RE: M/48/26/HH- Request for additional information.

Proposed North Elevation

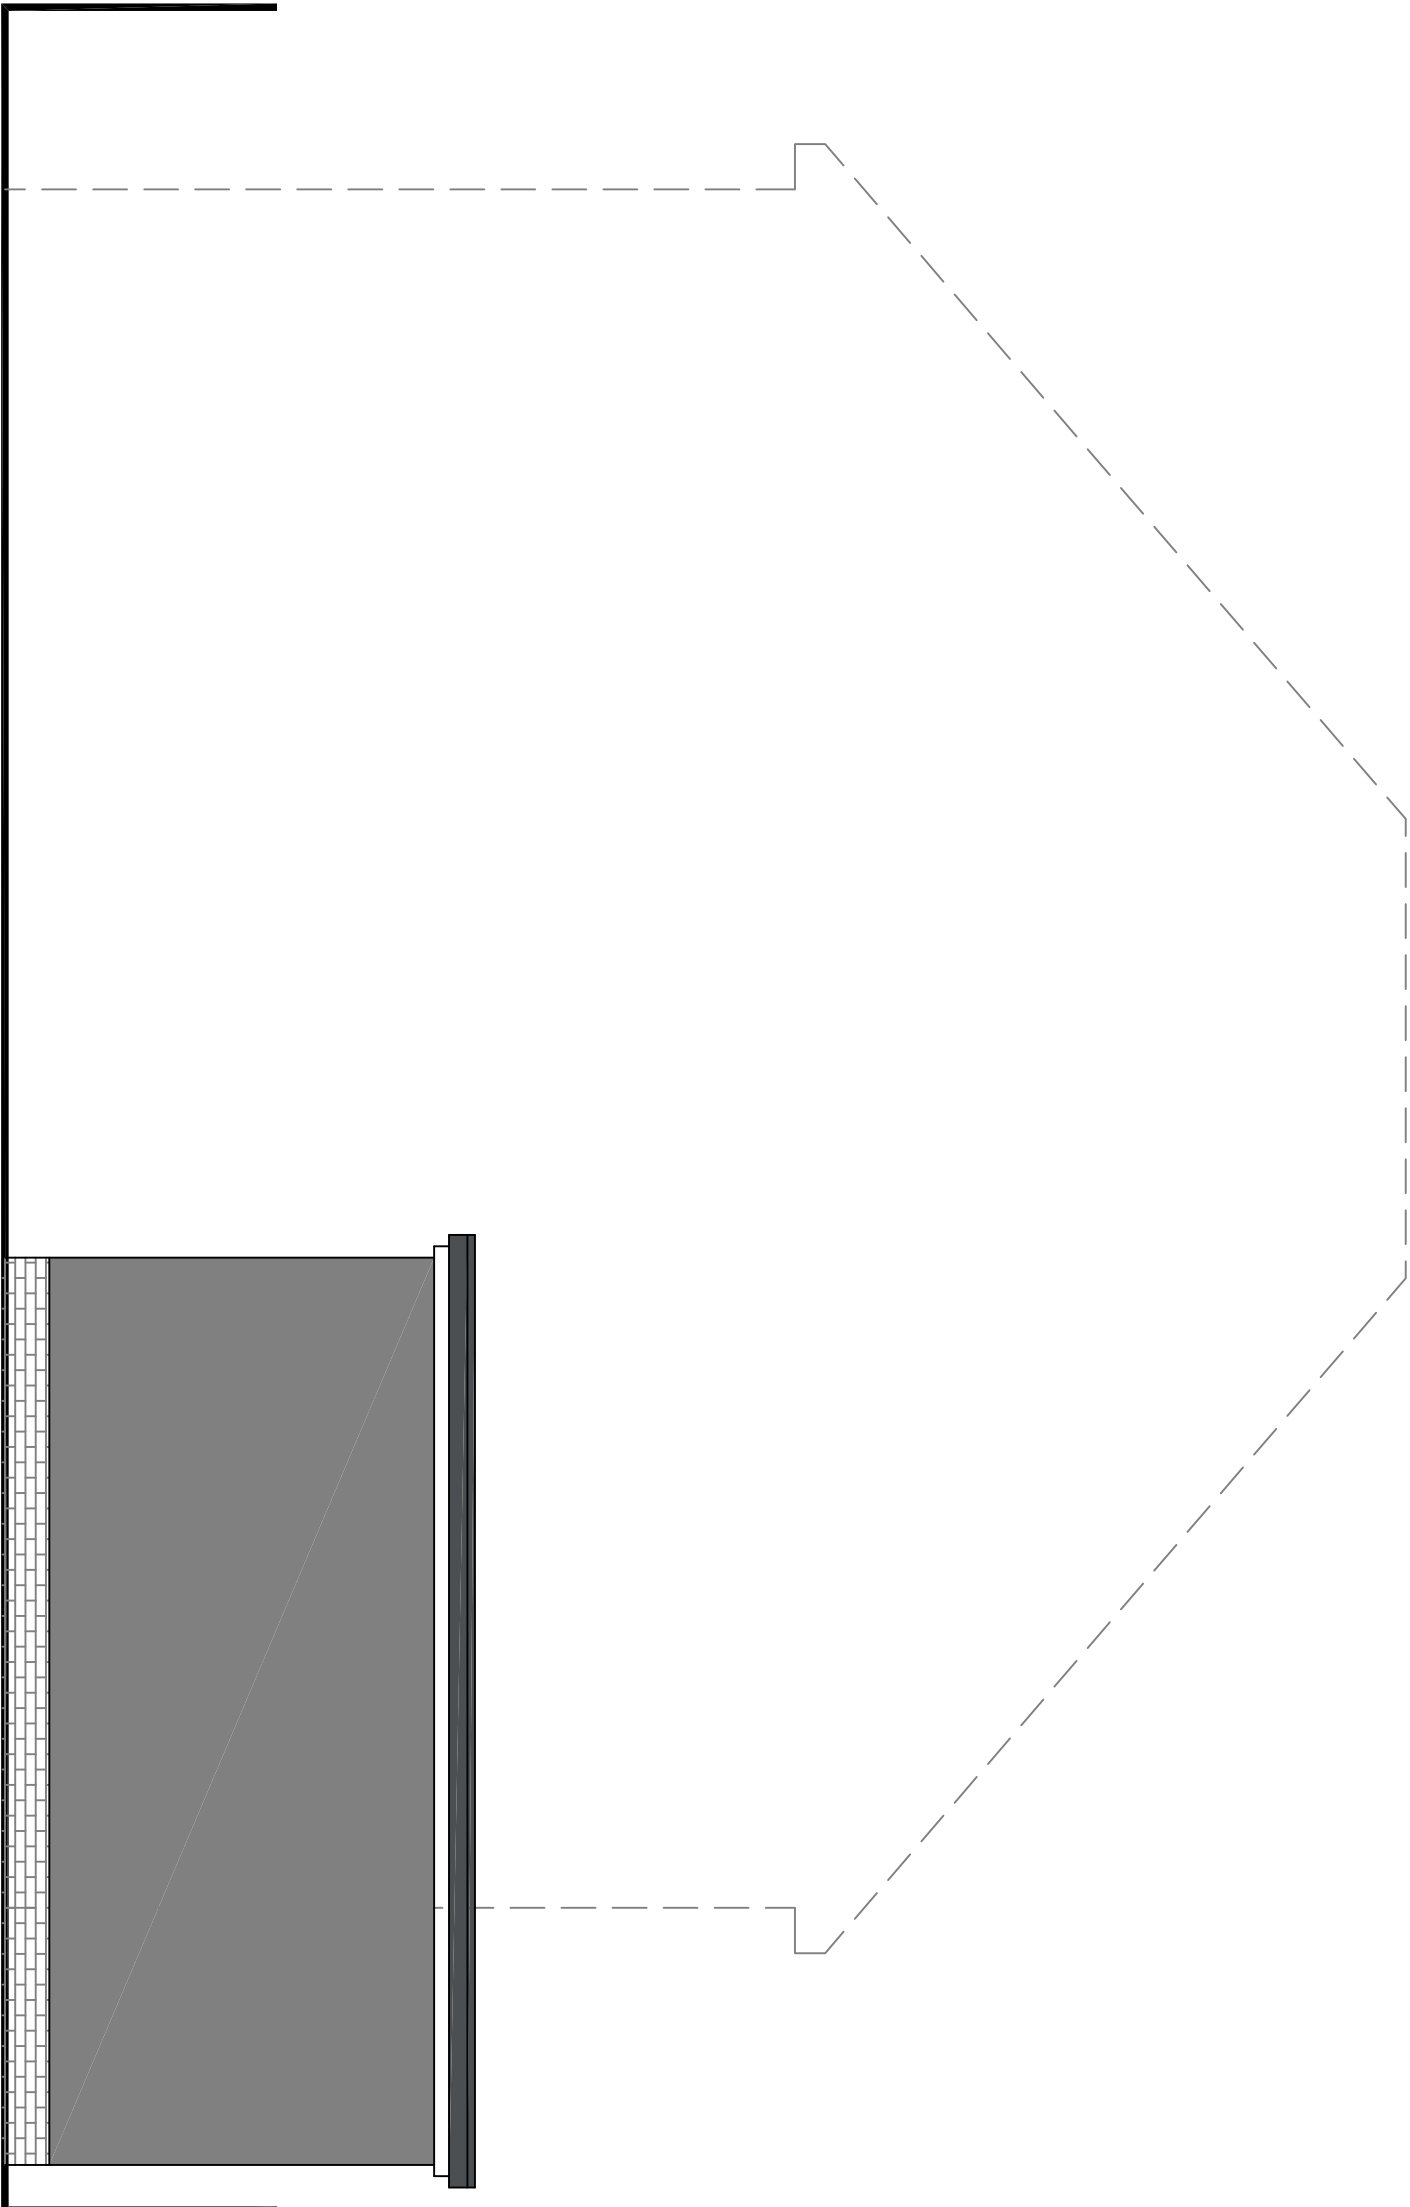
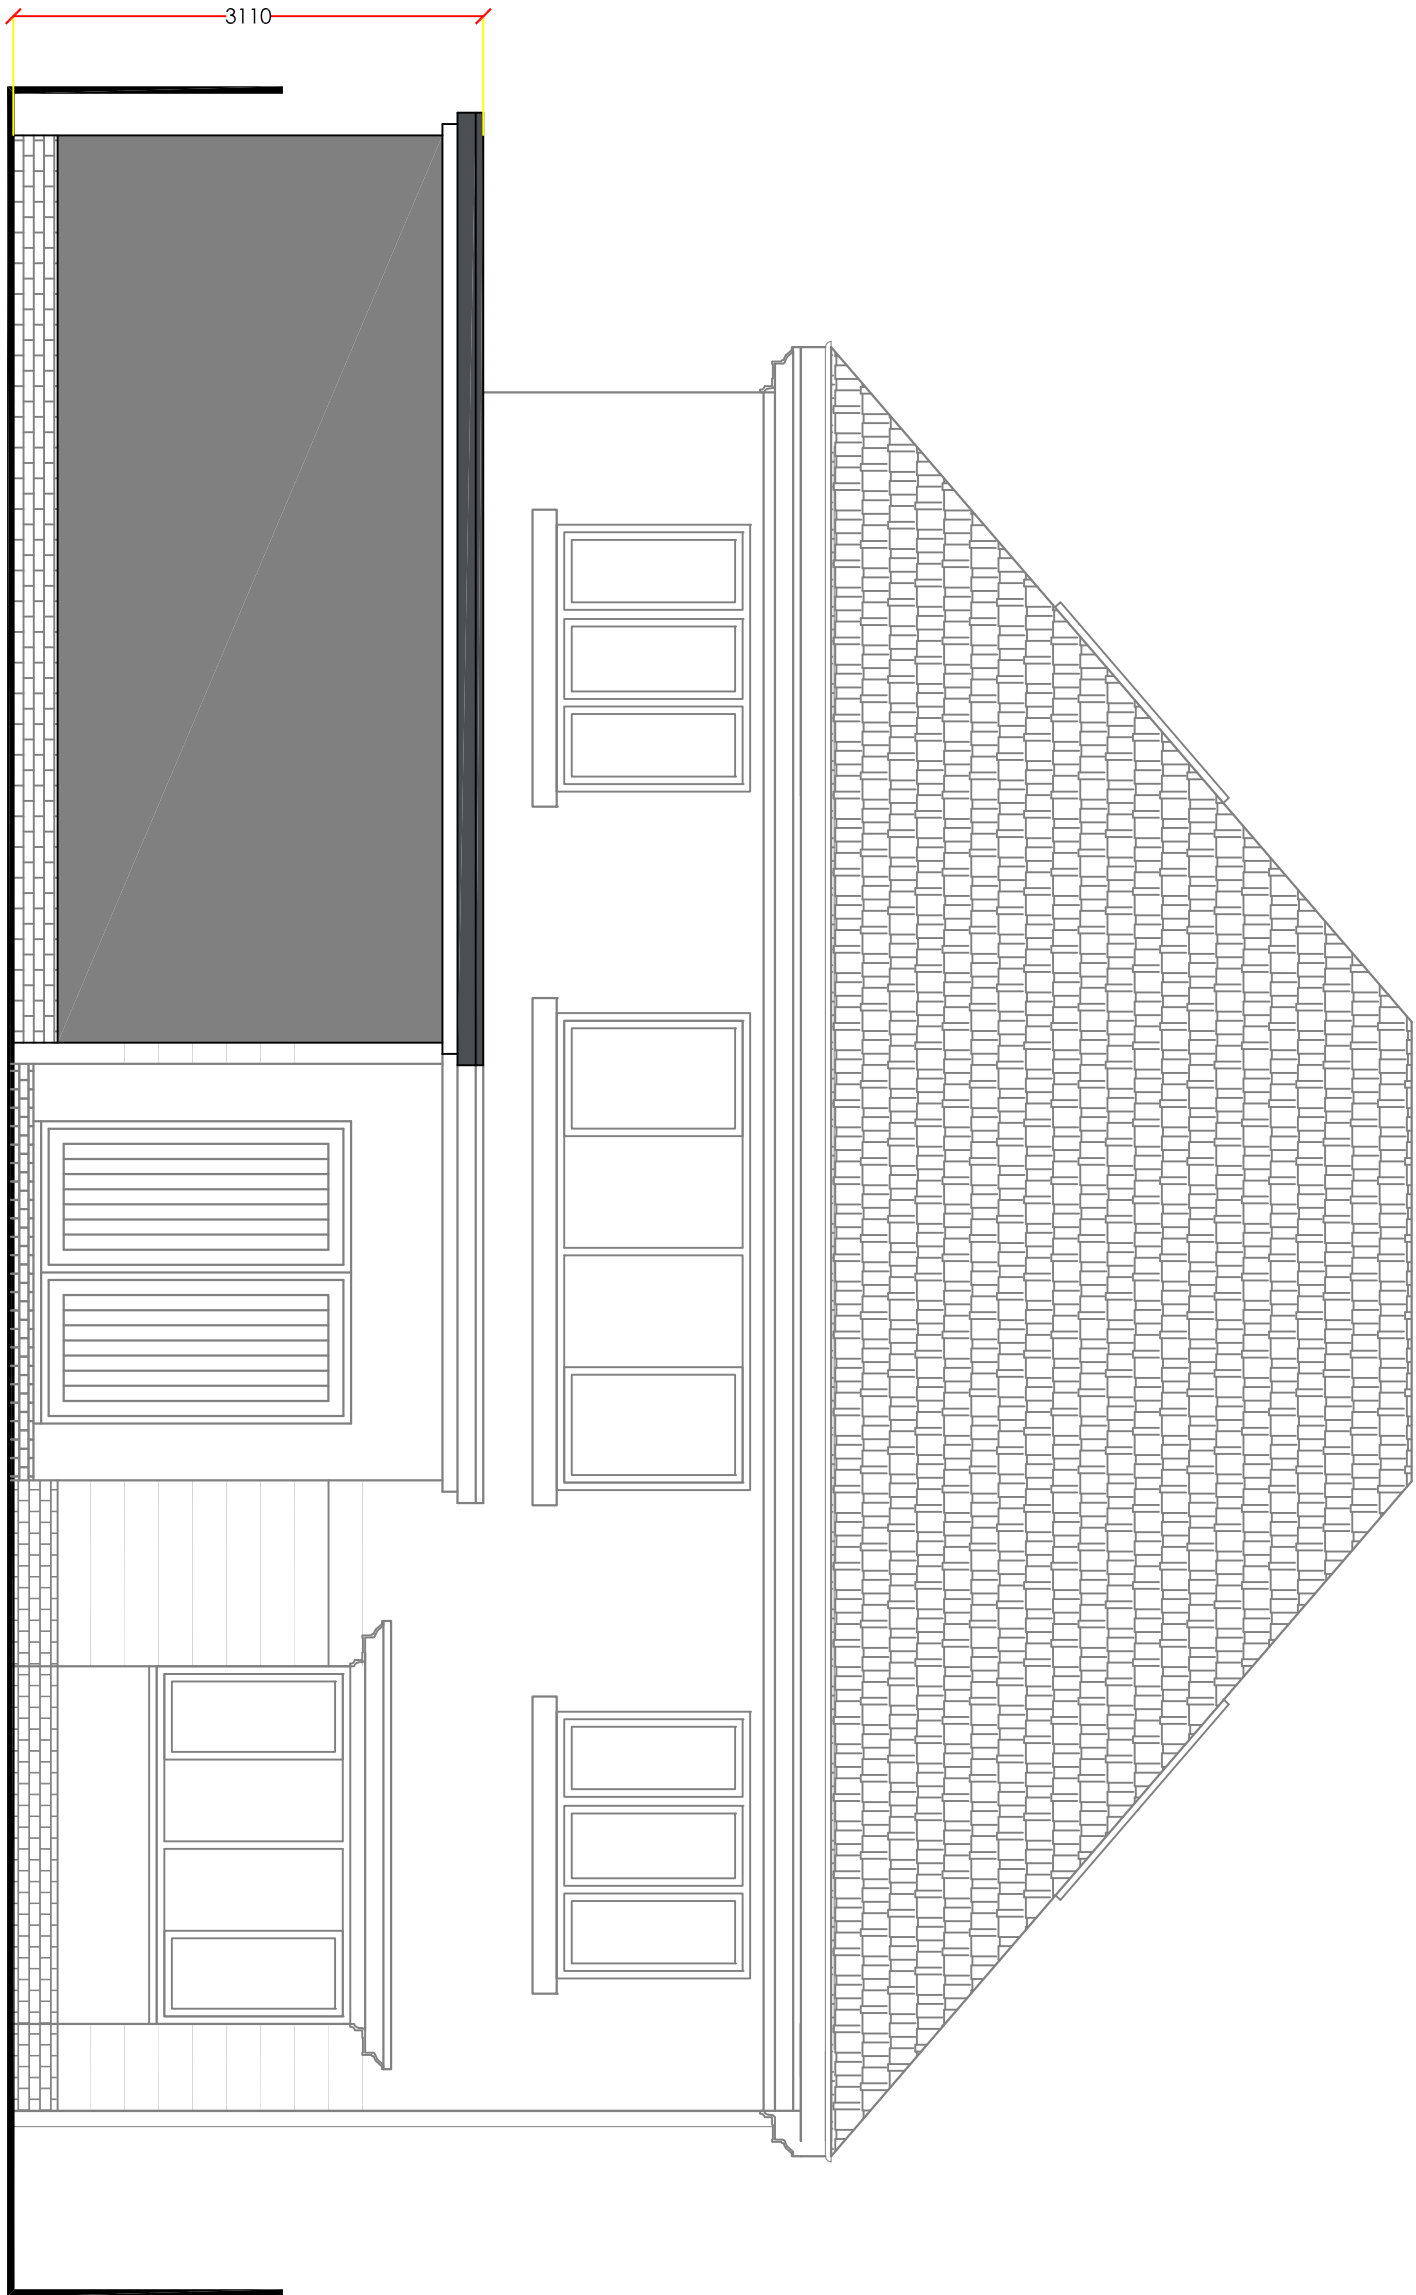
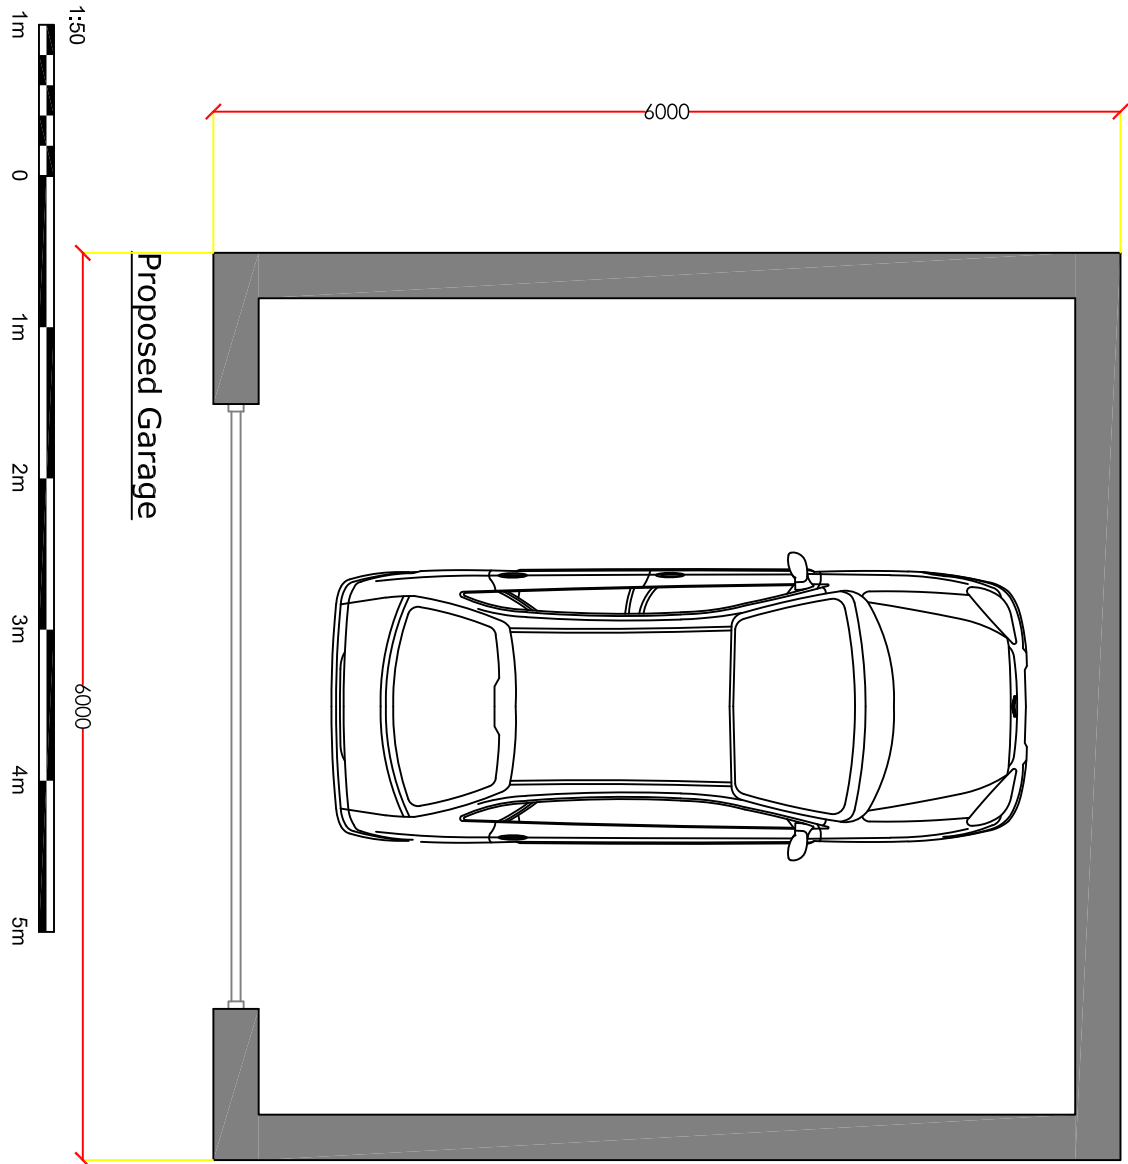
Below are some photos to show the inconsistencies I have mentioned: The plans for the application need to be consistent with the plans throughout any statement that you provide, as you can see the North elevations of the roof are inconsistent here.

The Proposed north elevation plan rooflights are still inconsistent with the plans visible in the Flood risk assessment and surface water drainage safety statement.
